B.A. McCurry  
**ENGINEERING**

Engineering -Stem Foundation Wall Observation - Footing Projection  
Lot 371 Oakmont Subdivision  
24 Tackett Court, Harnett County, NC  
Project No. 24PG-1125E BAM, Harnett County  
Permit No. SFD 2409-0078

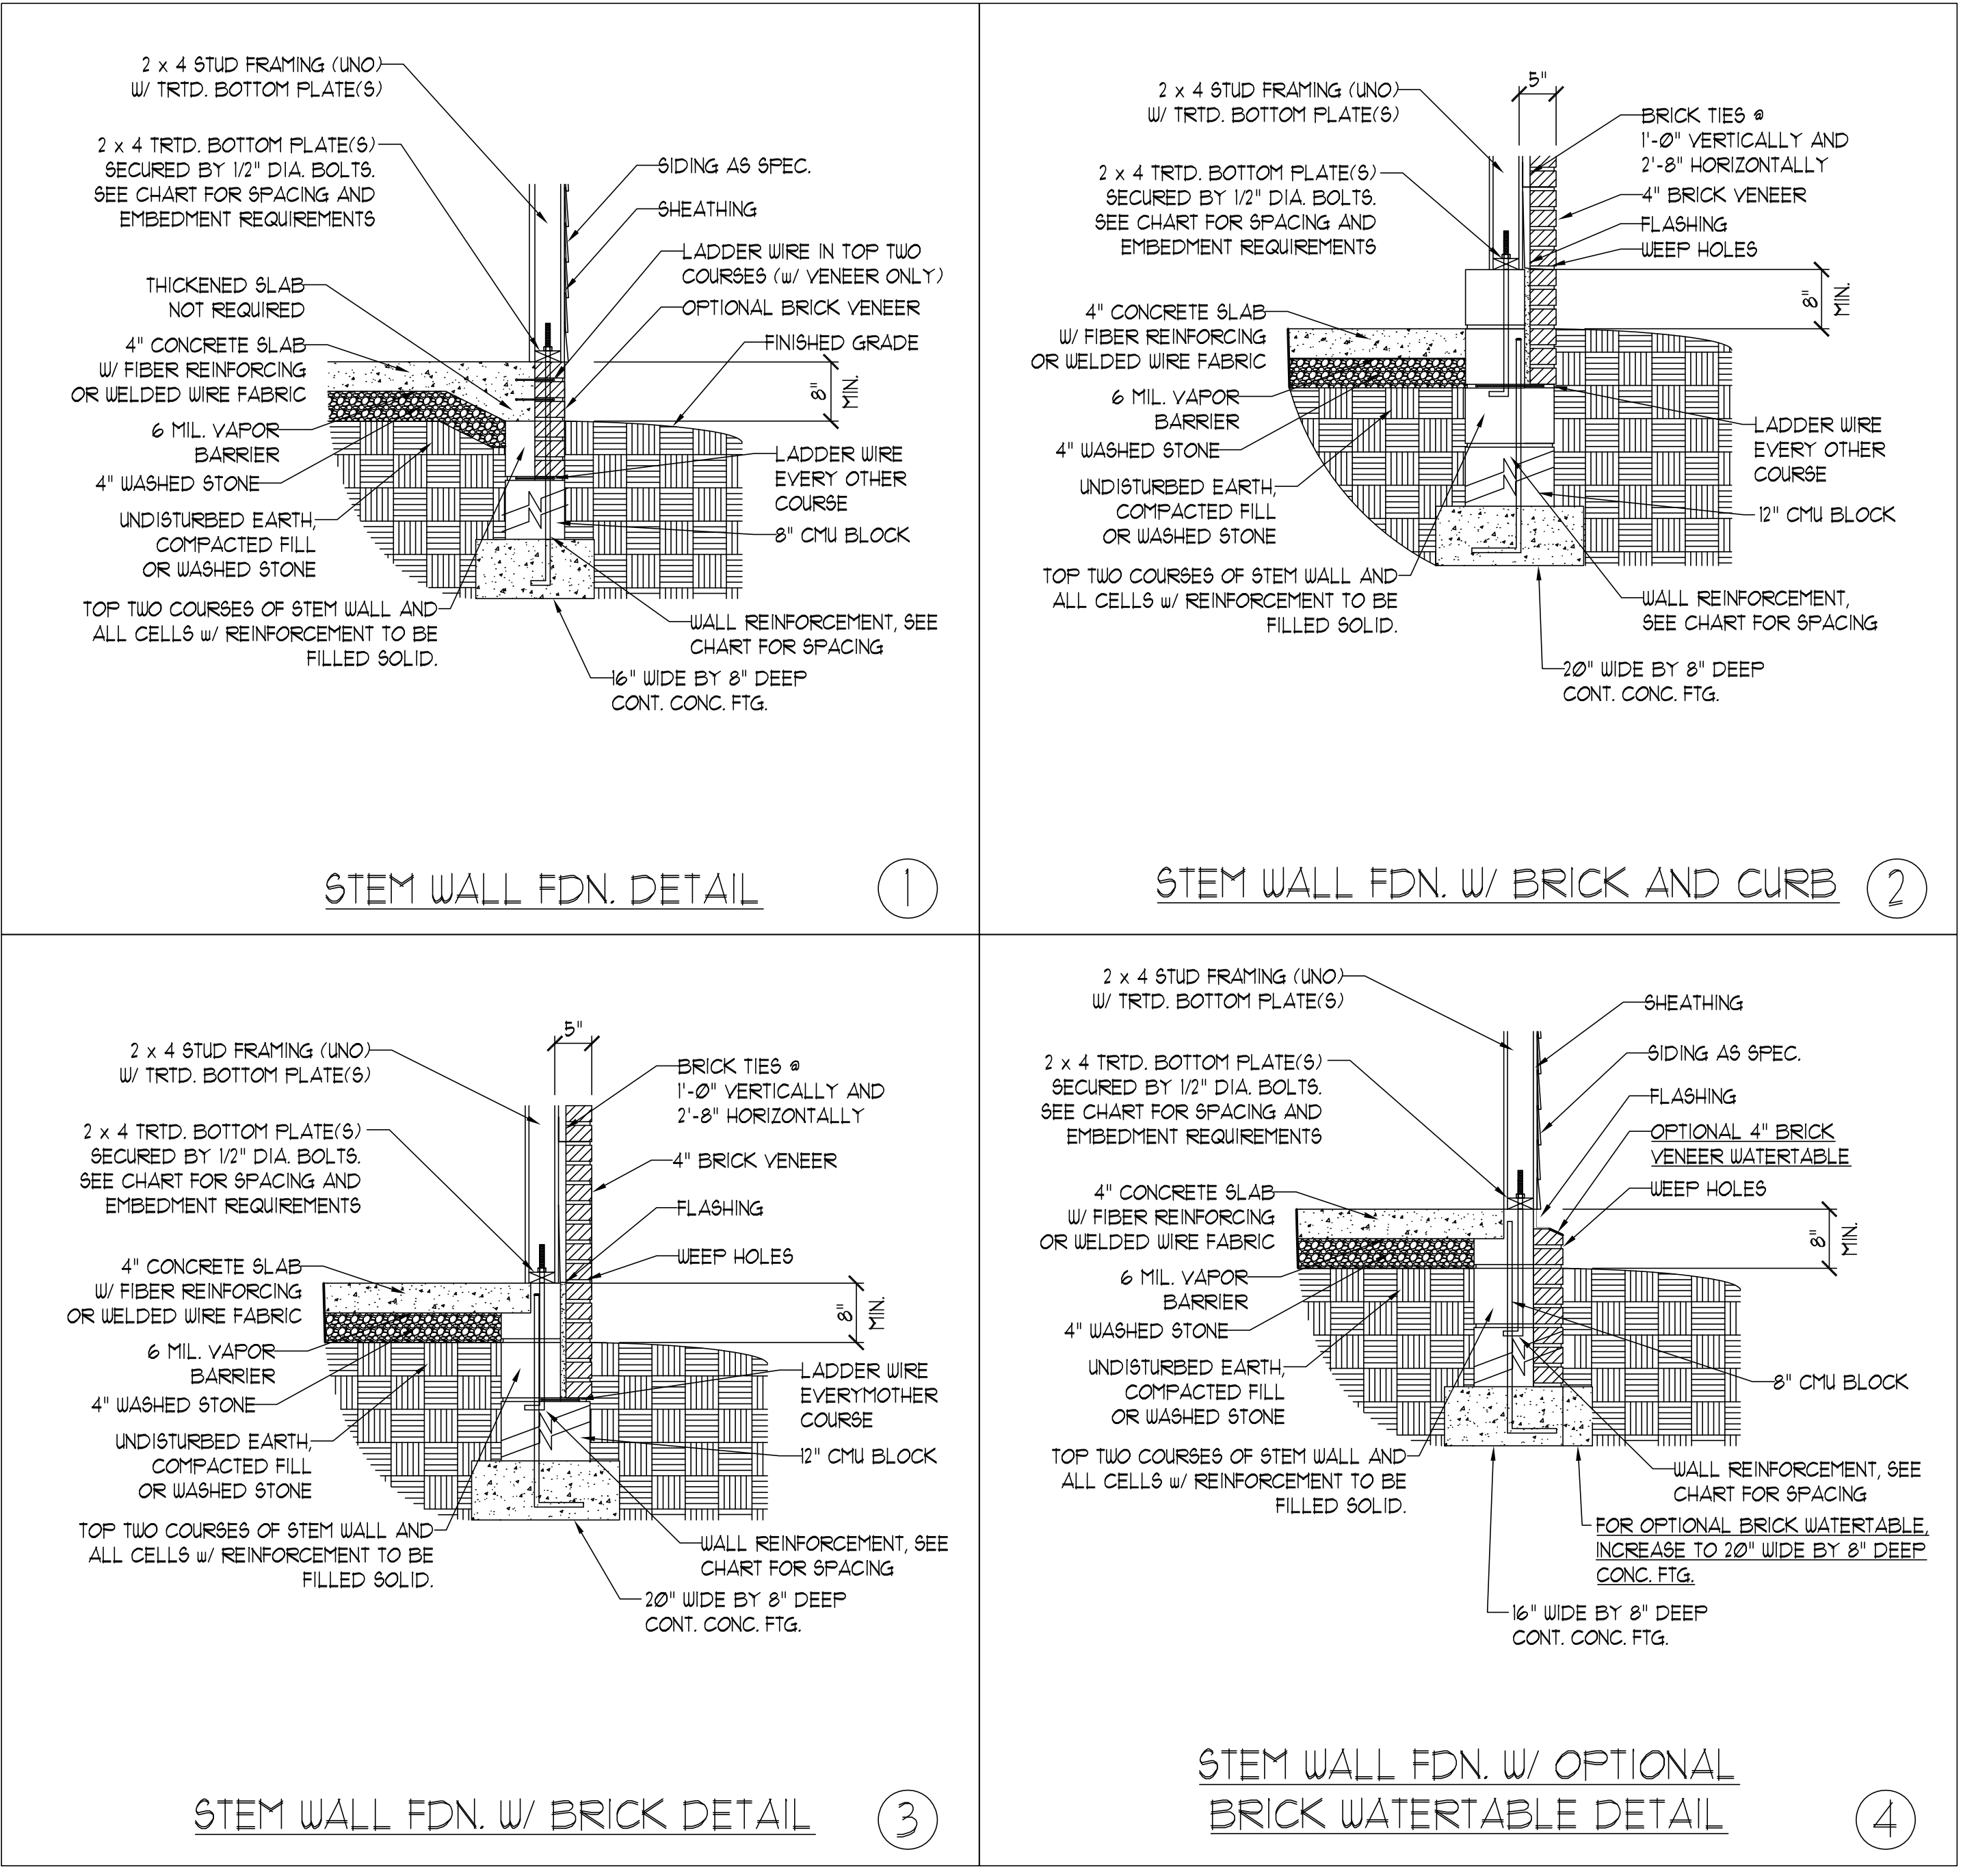
The CMU block walls were observed to be 8-inch CMU on the upper courses with 12-inch CMU block on the lower sections. The base of the wall was measured from the probed footing edges indicating adequate footing projection (within the middle third of the center of the loading of the walls).
